Ribble Valley Borough Council

DELEGATED ITEM FILE REPORT - APPROVAL

Application No:	3/2008/0514/P
Development Proposed:	Proposed first floor side extension to form en-suite and dressing room at Rake Bottom, Read, Burnley, Lancashire, BB12 7RD.

PROPOSED F.F. PLAN

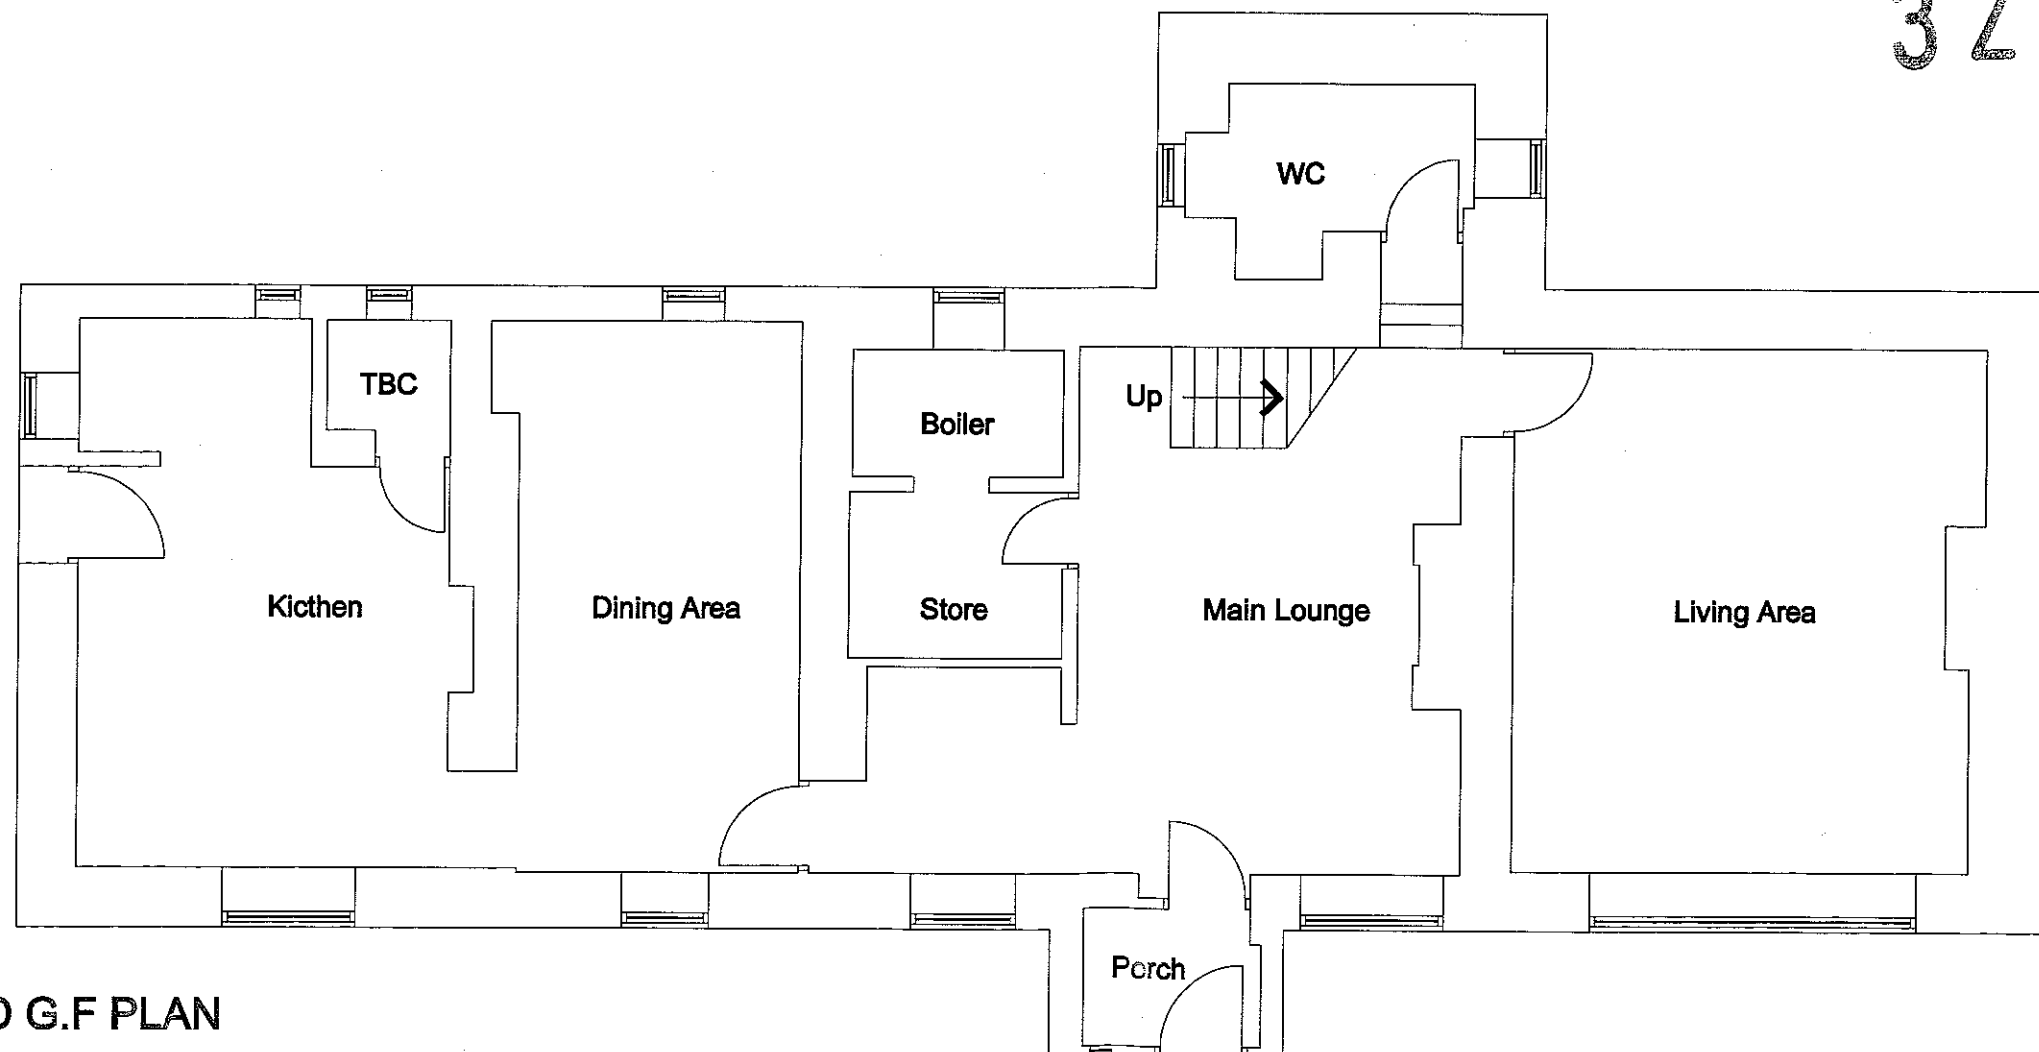
In terms of visual amenity, the design of the proposed extension is considered to be in keeping with this type of property and, indeed, there are other two storey extensions of similar design in the nearby vicinity. At the request of the Council, the proposed velux windows in the roof facing Whins Lane have been removed in order to keep this roofscape simple and to retain the character of the building. A new window has been placed in the side elevation to allow light into the en-suite, and as this will be obscure glazed, there will be no impact on the amenity of the nearby neighbours.

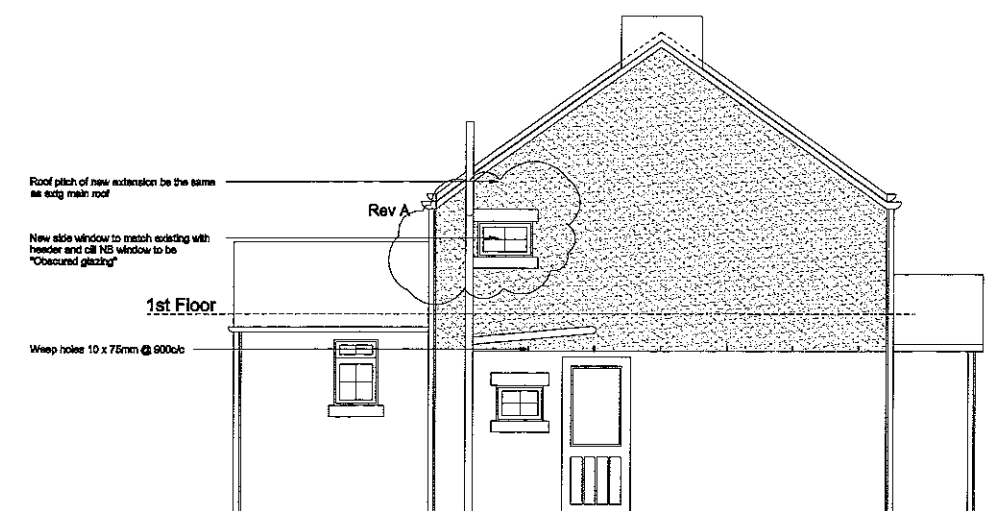
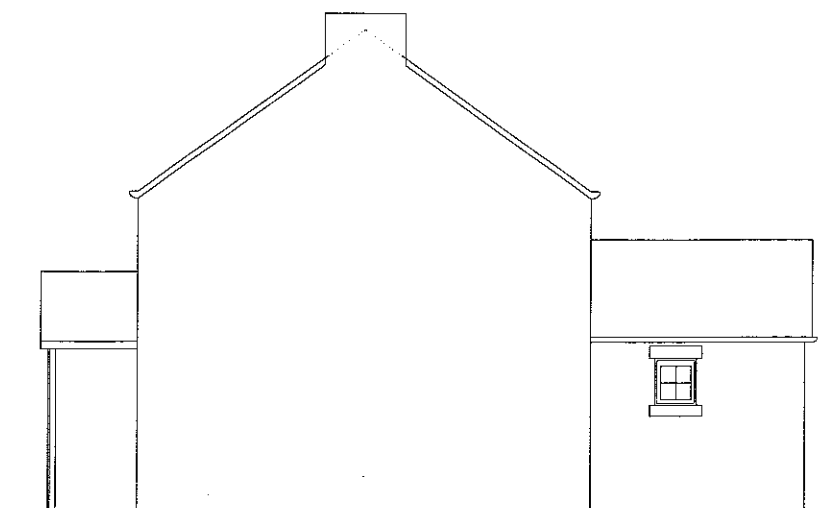
Planning permission is sought for a first floor extension over the existing single storey extension to the side of detached property within the settlement of Read. The proposed first floor element of the side extension has been designed set down from the existing roofline of the main property by approx 0.4m.
